**Consultation Response from KC,
Highways Development Management**
2020/92574 16, Upper Holme, Holme Lane, Slaithwaite, Huddersfield, HD7 5XD
Alterations and extensions to existing barn to form dwelling

Date Responded:04/09/2020	Responding Officer: Mark Berry	Responding Ref: 1-25-4
--------------------------------------	---	-------------------------------

Title. Site Plan

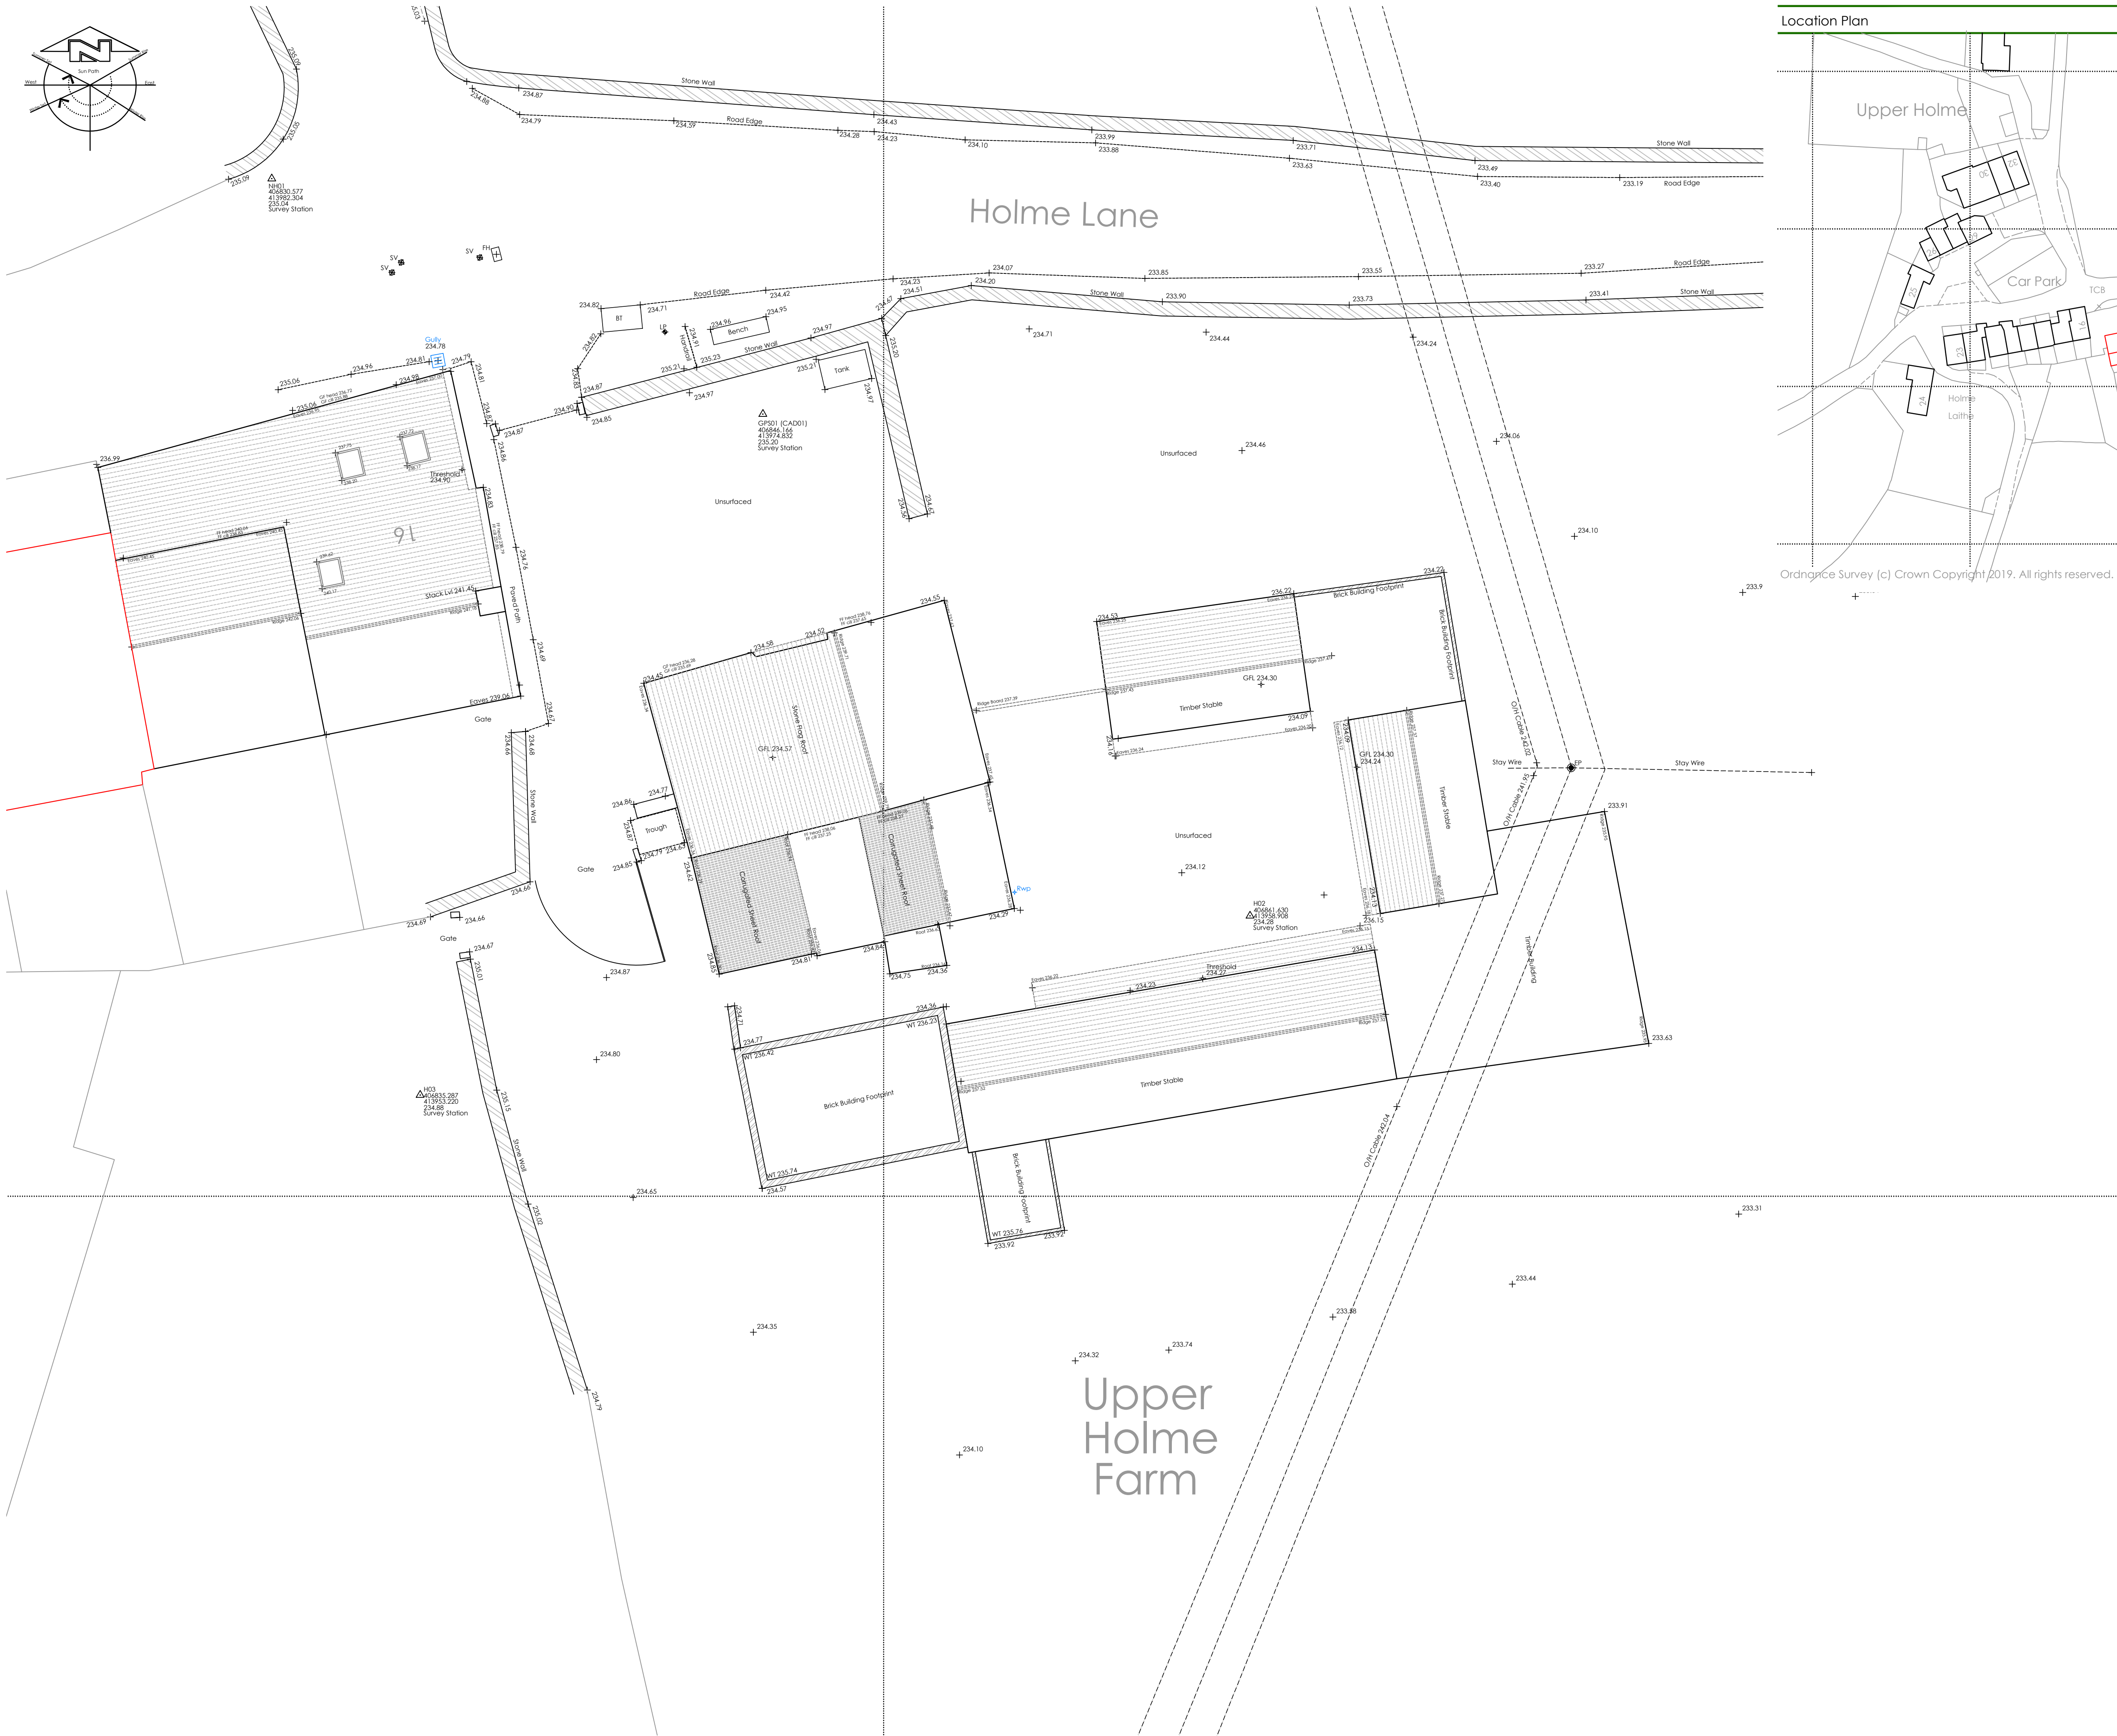
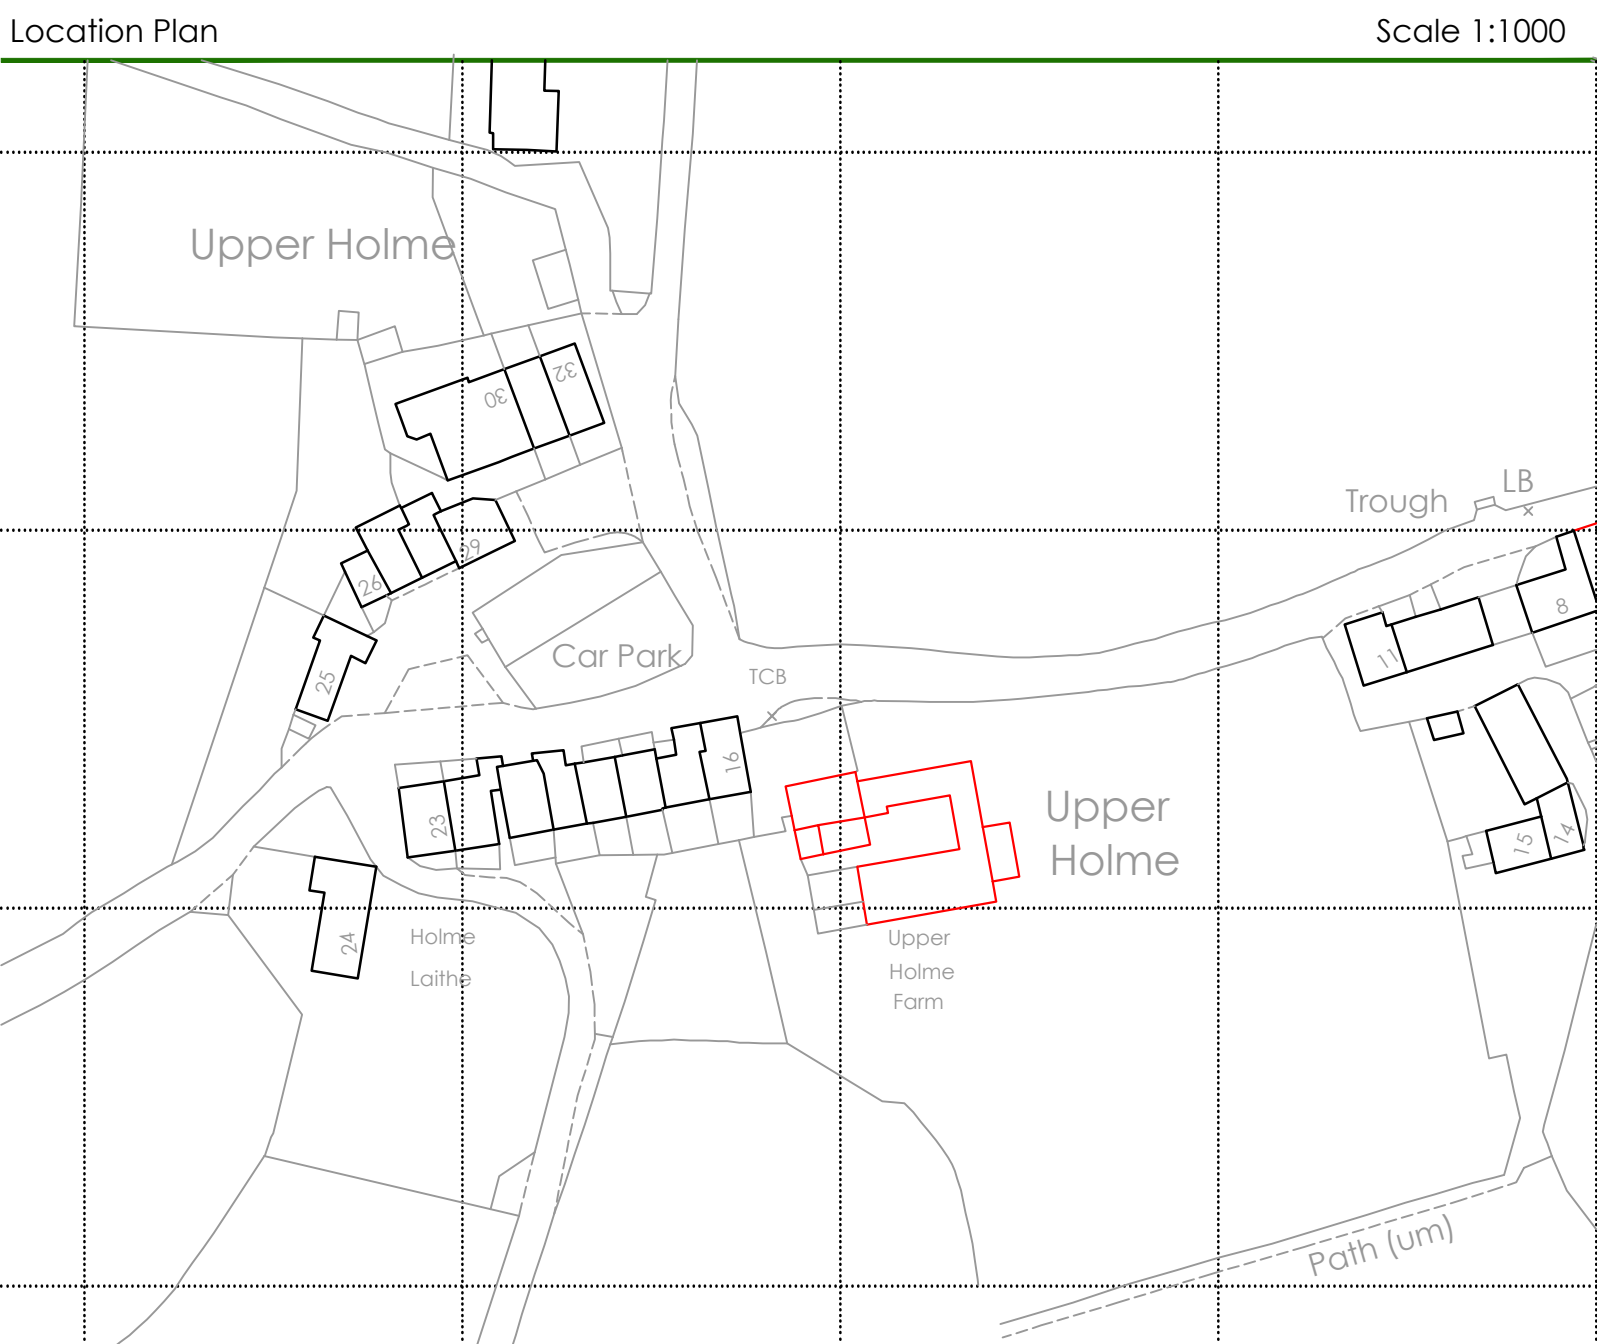
The existing access is shown to be retained. The off-street parking provisions are proposed to be within an area to the front of the proposed dwelling which also provides space for internal turning and manoeuvre.

Highways concern with this application is that sight lines from the existing access to the west or left when exiting are sub-standard due to the proximity of the adjacent building and the existing telephone box.

Highways Development Management would therefore recommend that the proposed access is moved to be close to the opposite boundary.

The plans should be amended to confirm that nothing shall be permitted to be planted or erected within a strip of land 2.0m deep measured from the carriageway edge of Holme Lane along the full frontage of the site which exceeds 1.0m in height above the level of the adjoining highway

Bin collection points should be shown to be provided to enable bins to be presented on collection day without either obstructing the highway or proposed driveway.
